Our Ref: FG/162/17/PL
Your Ref:

Town & Country Planning Act 1990 (as amended)
Town and Country Planning (Development Management Procedure) (England) Order 2015
Application for Planning Permission

Development Demolition of existing detached garage & erection of 1 No. dwelling.
Location 1 Upper West Drive Ferring

EXISTING SITE PLAN 1:100

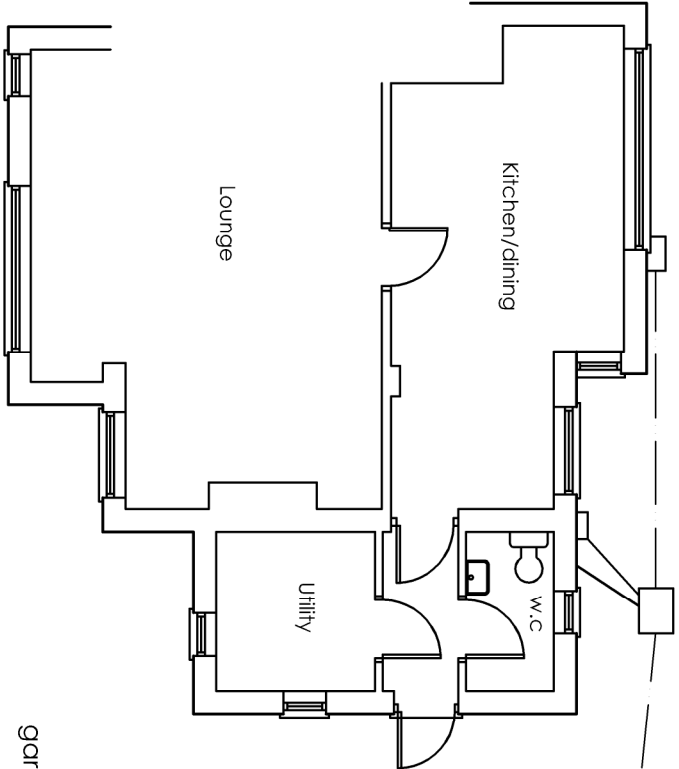
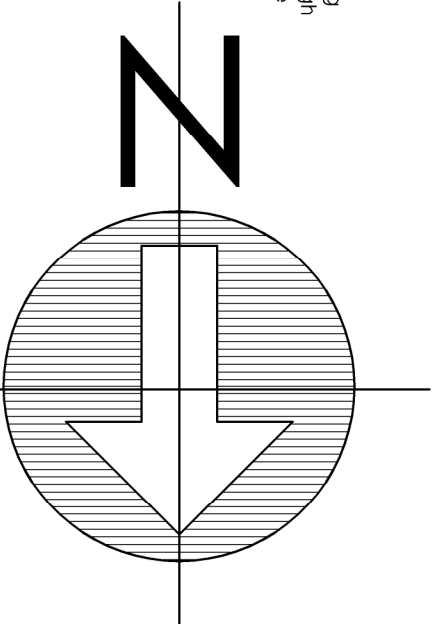
The red and blue edges on the location and site plan need to be amended. Please red edge the application site and blue edge any land adjoining the application site that is in control/ownership of the applicant.

On the site plan, please include the proposed access within the red edge.
